Submission on Stage 1 Concept Modification Application (SSD-8874-Mod-1)

# 7.3 MODIFIED ENVELOPE INDICATIVE GROUND FLOOR

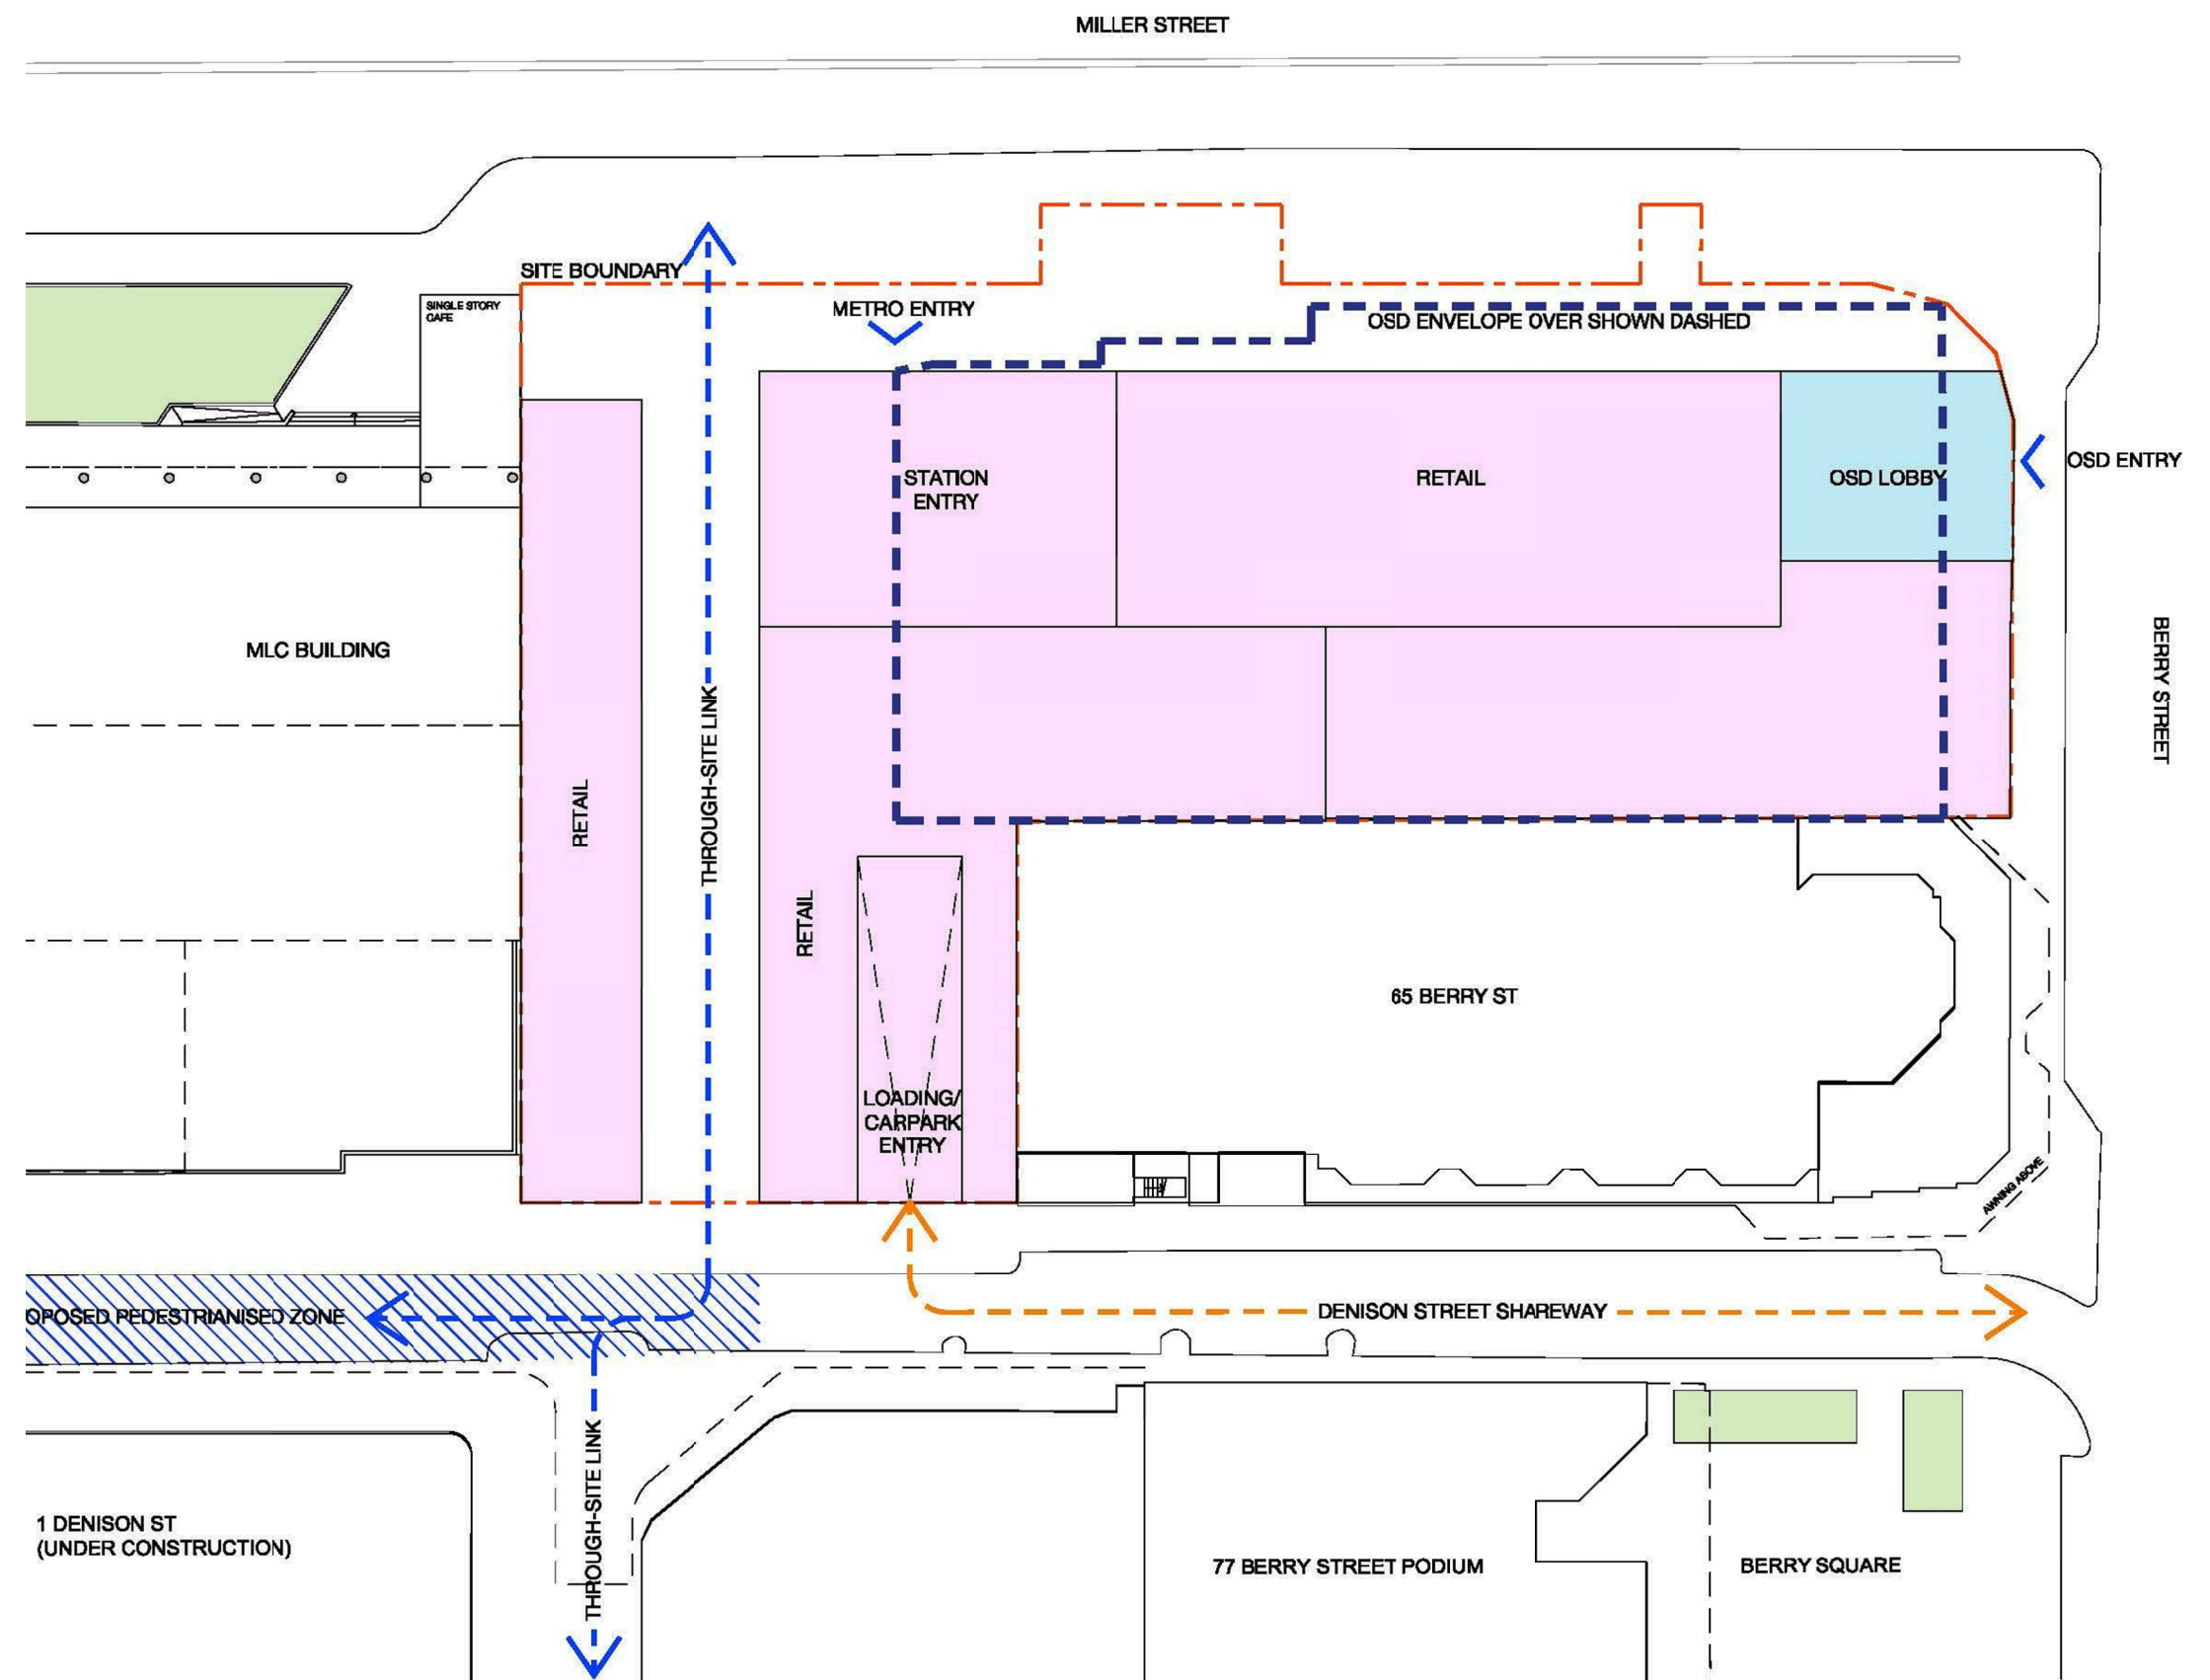
25. This plan offers a widened footpath area fronting Miller Street with only about 2m pedestrian paved area along the kerb of Miller Street which is completely inadequate for the current and future pedestrian traffic. The building setback is cluttered with raised grassed area and series of ramps and fenced outdoor platforms in front of the retail shops strictly privatising this very scarce and needed public space.

26. The suggested approach to public domain proposal for Miller Street frontage is considered unacceptable and bad urban design outcome for this hub of pedestrian activities in the CBD. The design should be maximising the circulation space and providing a flexible, level and generous plaza with shade trees and series of seats under trees fully integrating it with the Council’s proposed widening of the existing pedestrian area in Miller Street.
